KITTITAS COUNTY

MEMORANDUM

TO: Jeff Watson, Community Development Services
FROM: Christina Wollman, Planner II CW
DATE: November 9, 2010
SUBJECT: Graybill BL-10-00039

Graybill SP-09-00006
AFN 201010110007

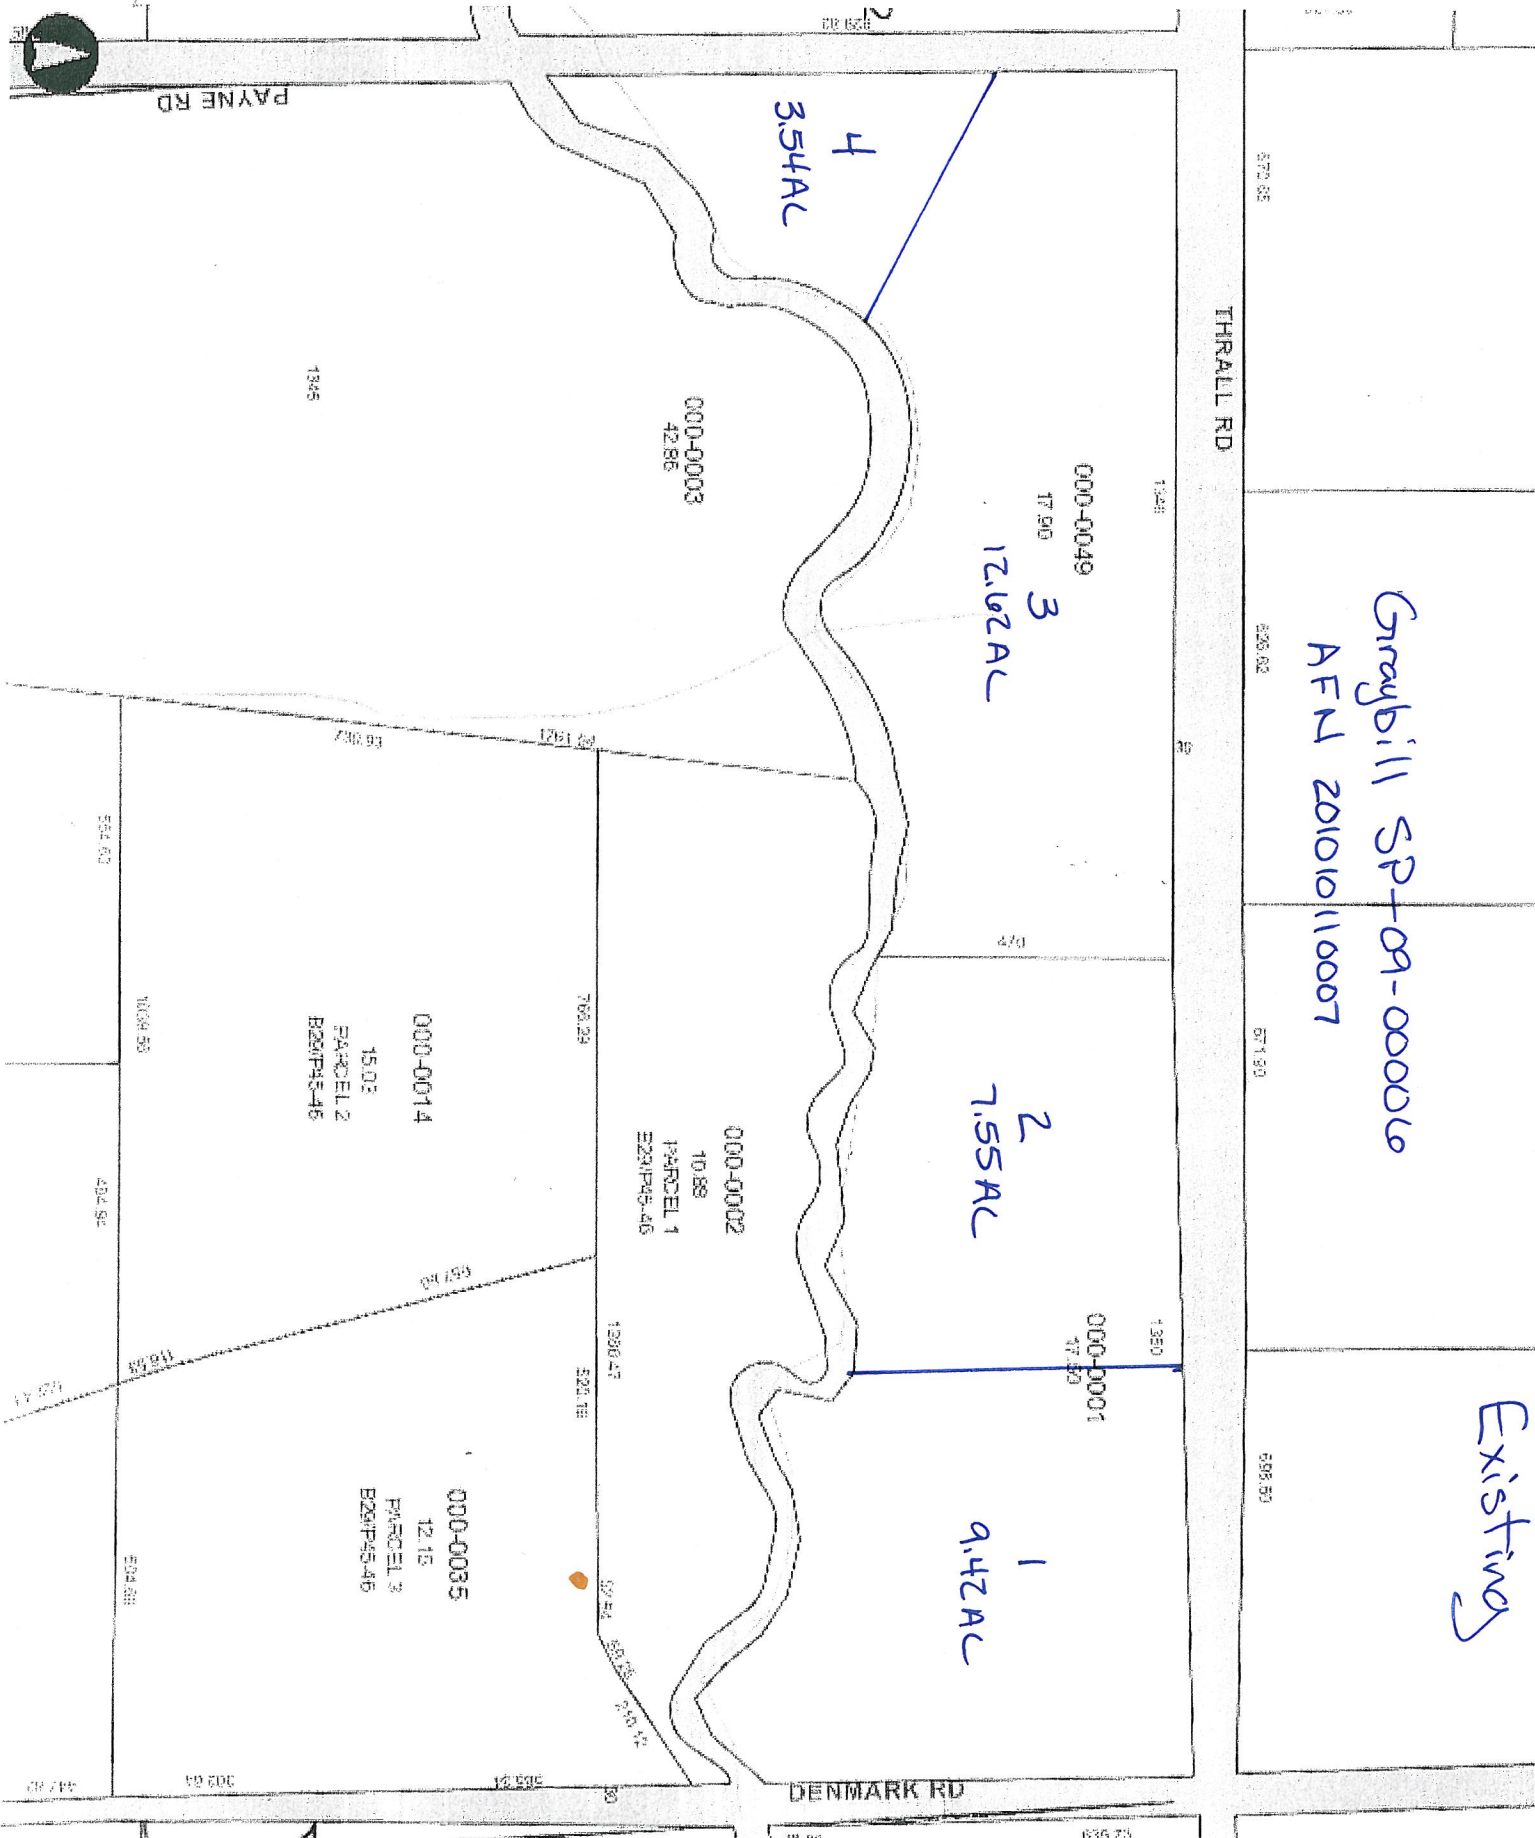
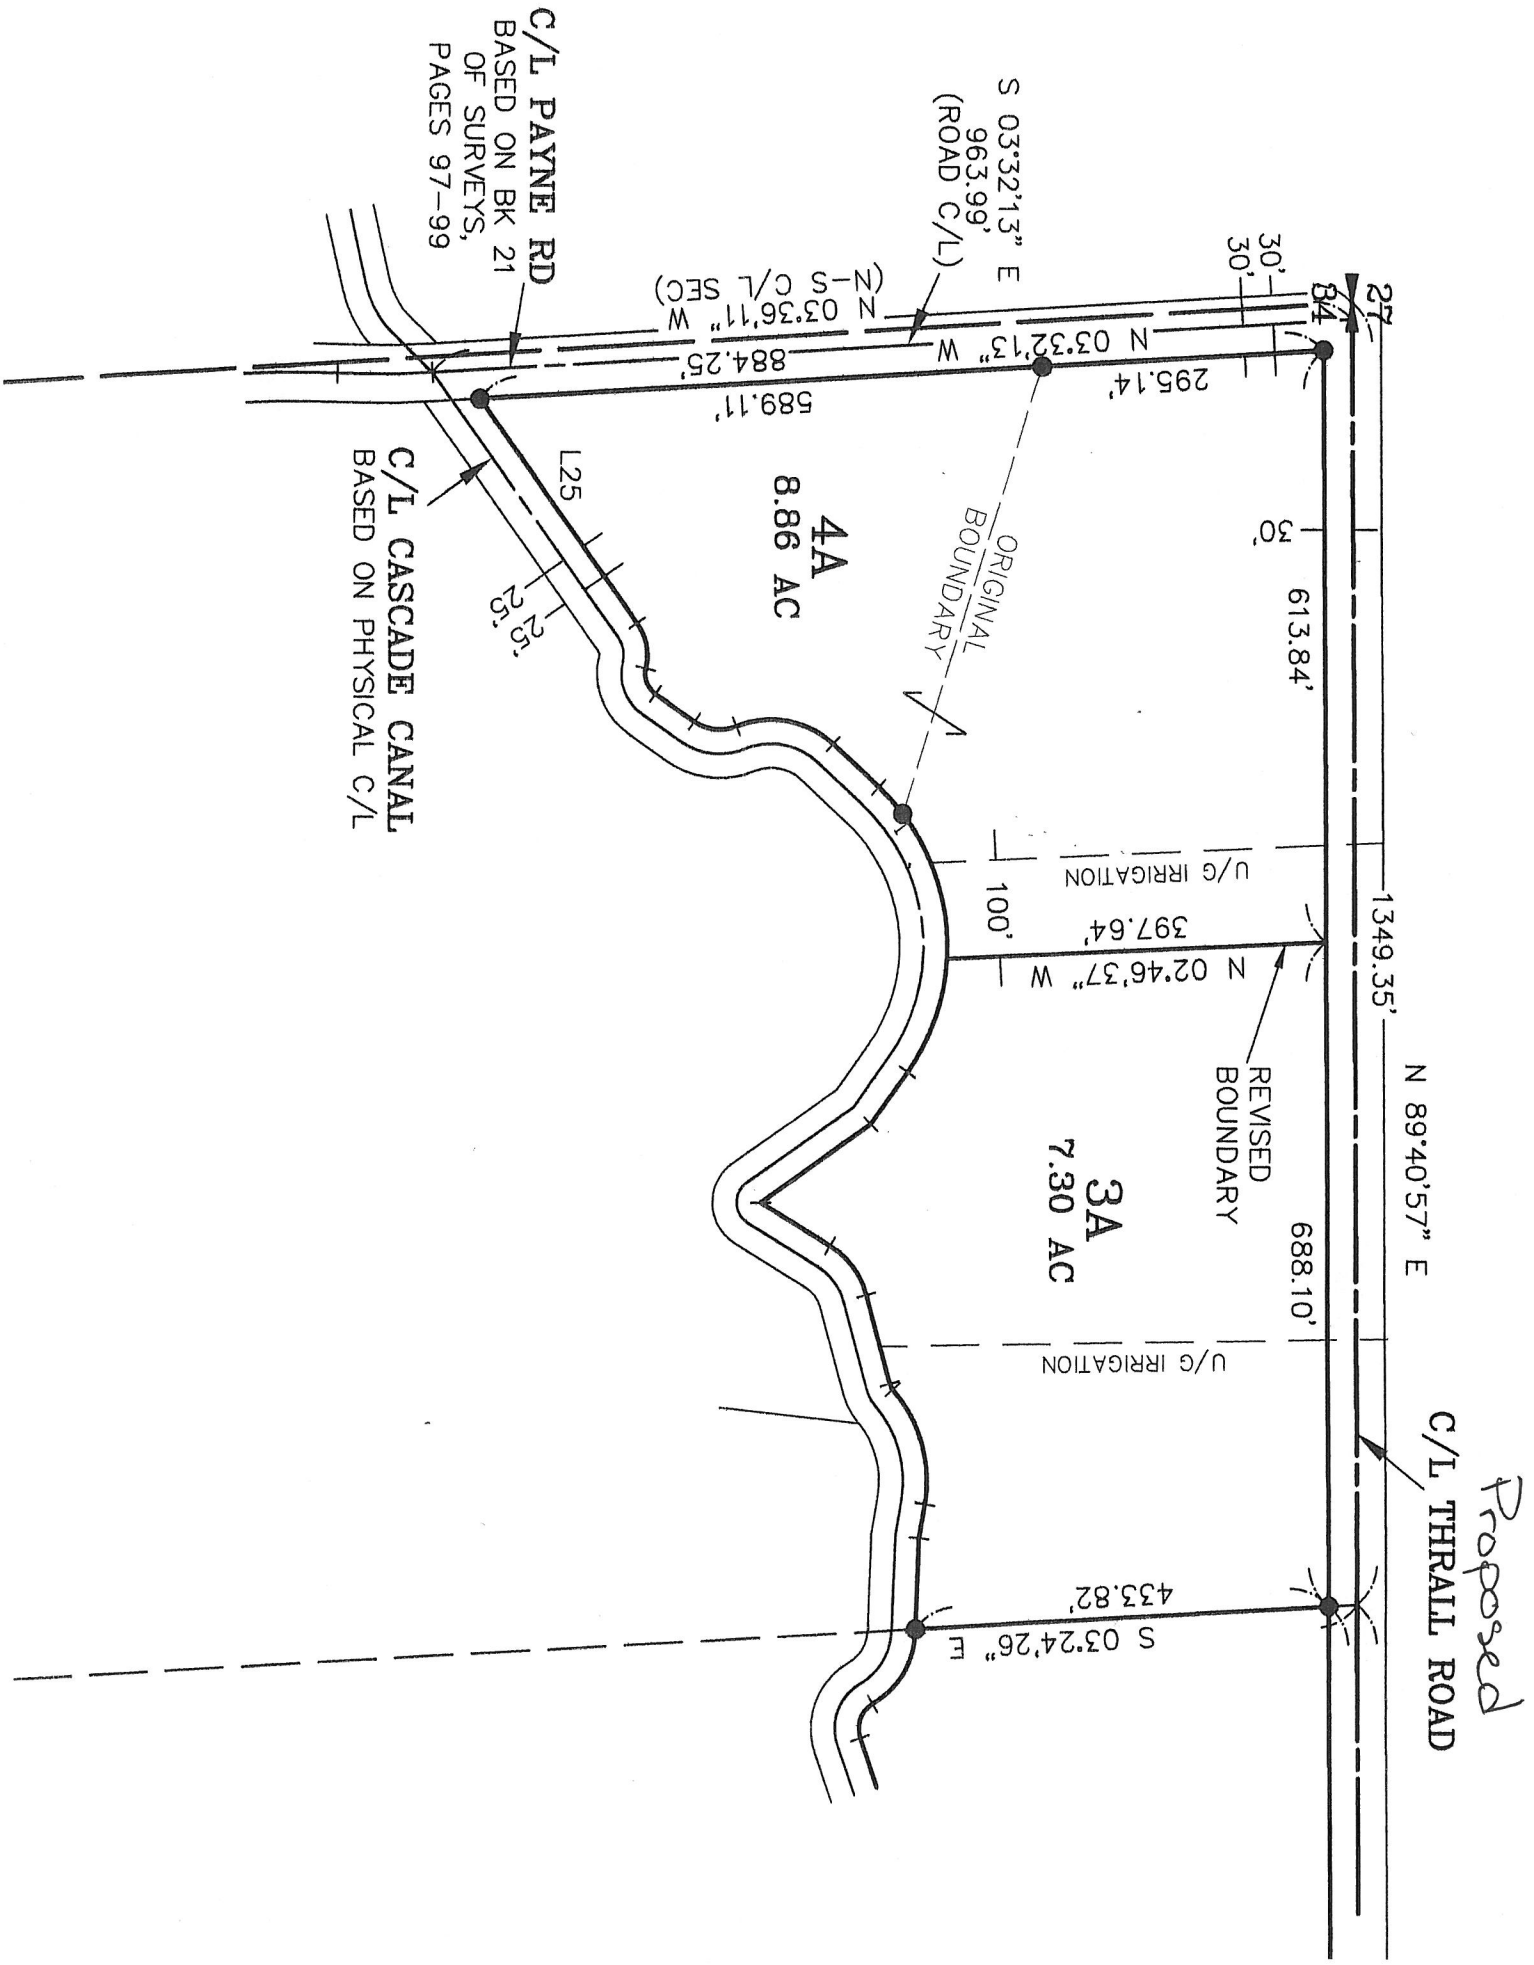
- a. Access to Lot 4 shall be from Payne Road.
- b. An approved access permit shall be required from the Kittitas County Department of Public Works prior to creating any new driveway access or performing any work within the county road right of way.
- c. Maintenance of driveway approaches shall be the responsibility of the owner whose property they serve. The County will not maintain accesses.
- d. Any further subdivision or lots to be served by proposed access may result in further access requirements. See Kittitas County Road Standards.
- e. Evidence of existing access and/or evidence of access to be created should be confirmed prior to sale of property.
- f. Access is not guaranteed to any existing or created parcel on this application.
